Application for Planning Permission for Works or Extension to a Dwelling

Development: Detached garage in compound.
Location: 75 Mayfield Close Pagham PO21 3PS

GROUND FLOOR PLAN

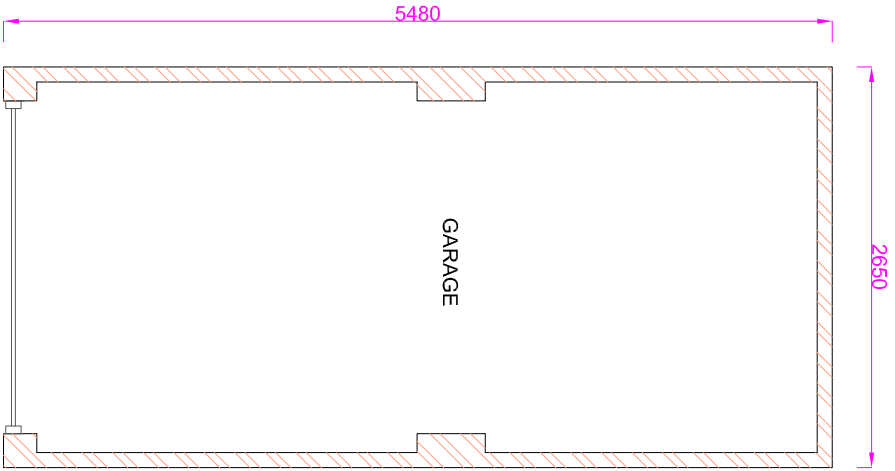
Room Labels: You are required to have room labels on all floor plans. Please amend.

Site Plan (scale 1:500)

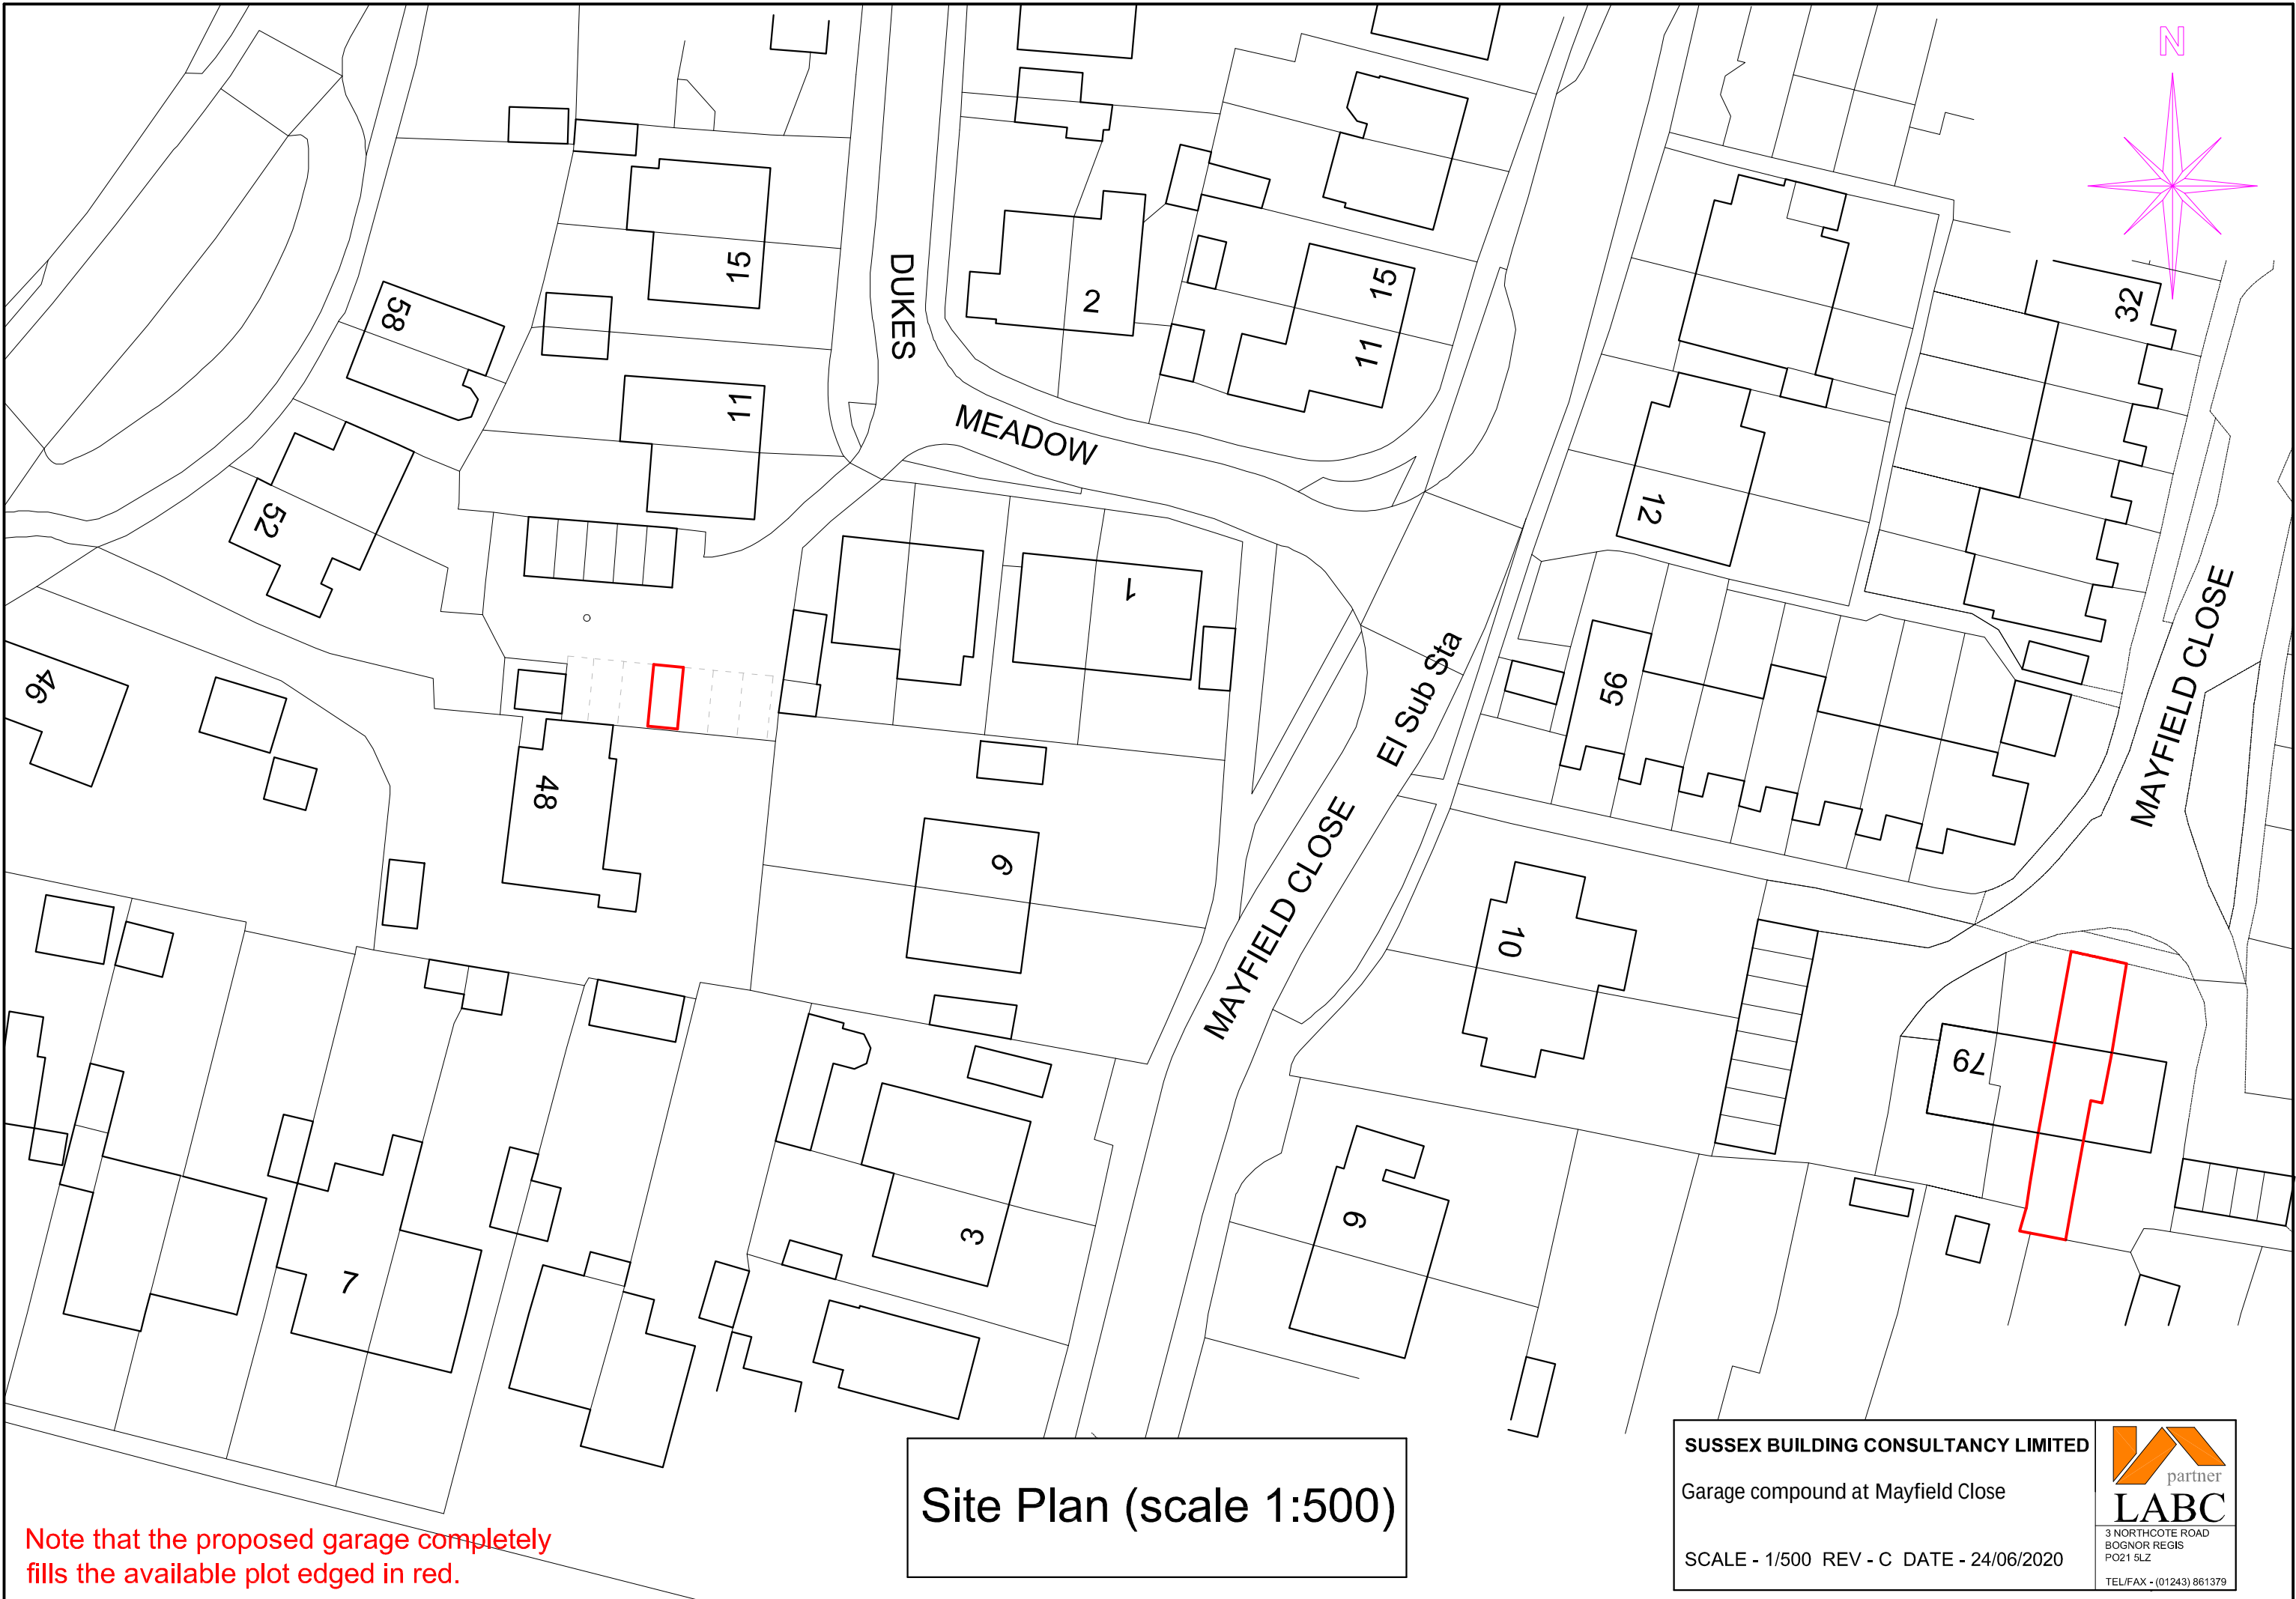
Block Plan: Please submit a proposed block plan with dimensions to all site boundaries.
